Re: Response to Colorado Geological Survey Review
Soil, Geology, & Geology Hazard Study
Sterling Ranch East – Preliminary Plan No. 1
Parcel Nos. 17, 18, 22, 23, 24, 26, 37, & 38
El Paso County, Colorado
Entech Job No. 220571

CGS COMMENTS AND ENTECH ENGINEERING, INC. RESPONSES

EP-22-0102_1 Sterling Ranch East Phase I PUDSP224

PRELIMINARY SITE PLAN

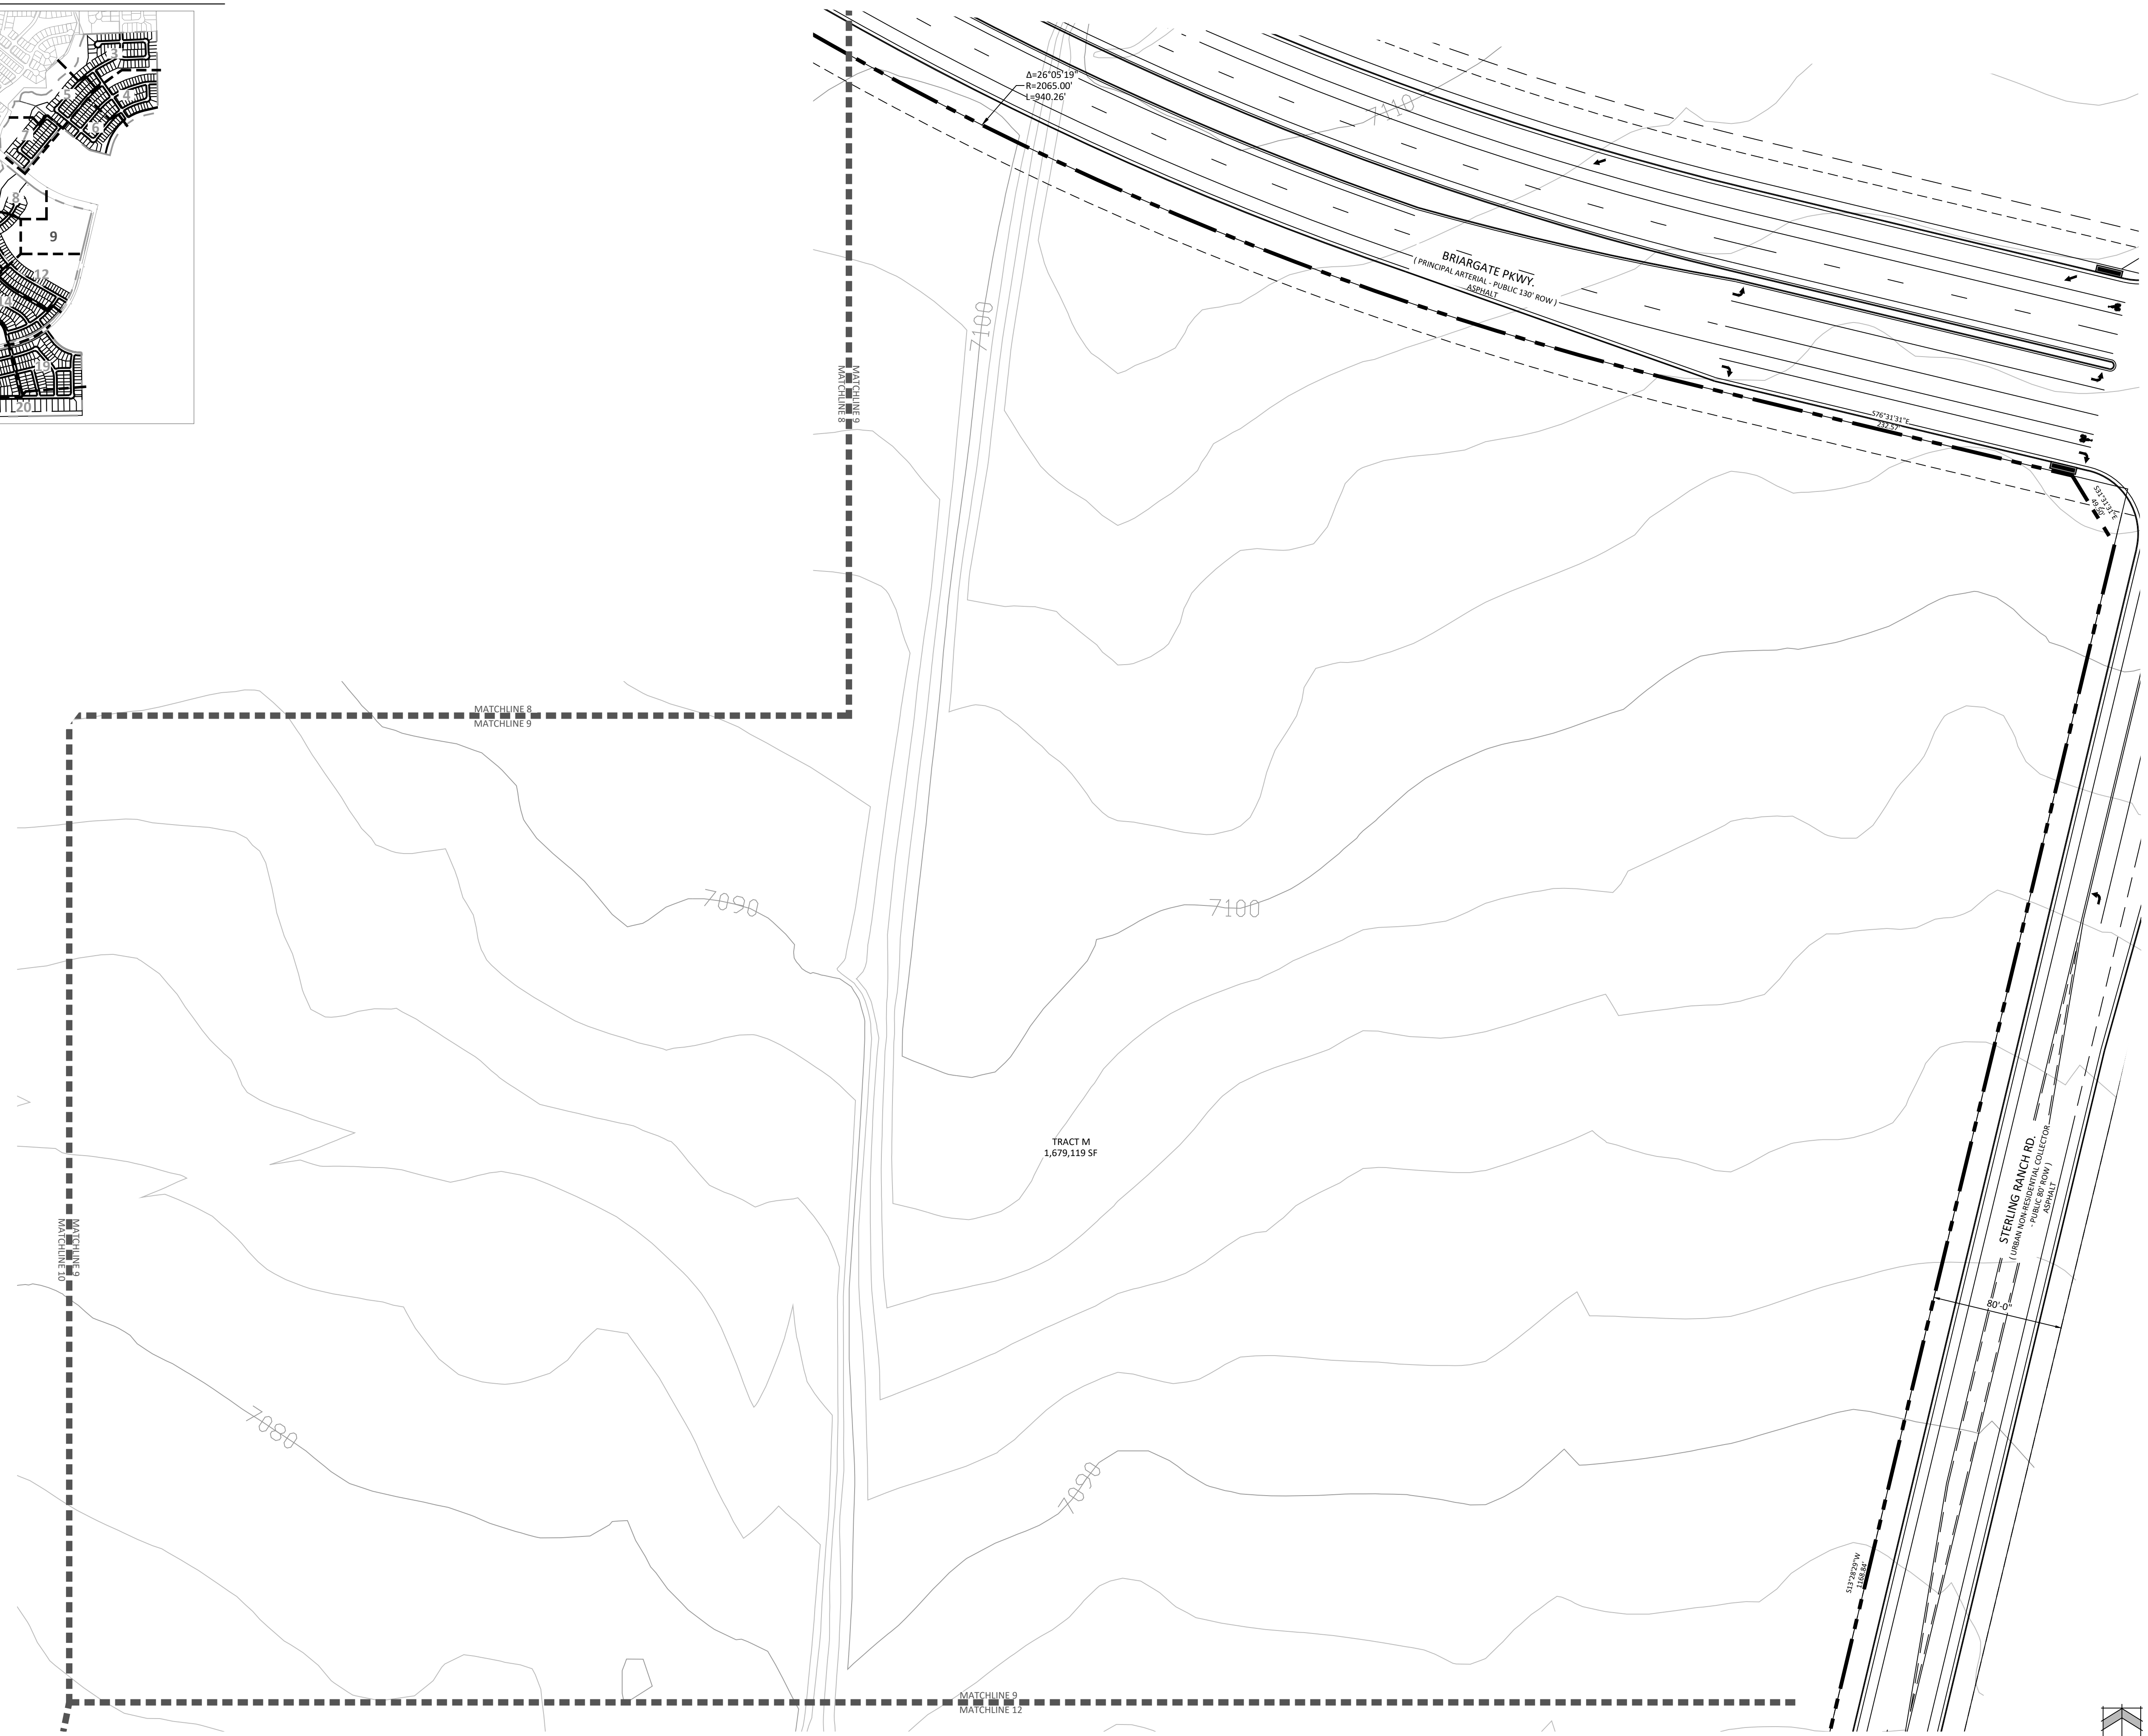
1. Sheet 1 of the preliminary plan shows Filing 3 to the north of Sterling Ranch Rd. and north of Briargate Pkwy. Our review of the grading plans indicates that the parcel north of Sterling Ranch Rd. is Filing 1.
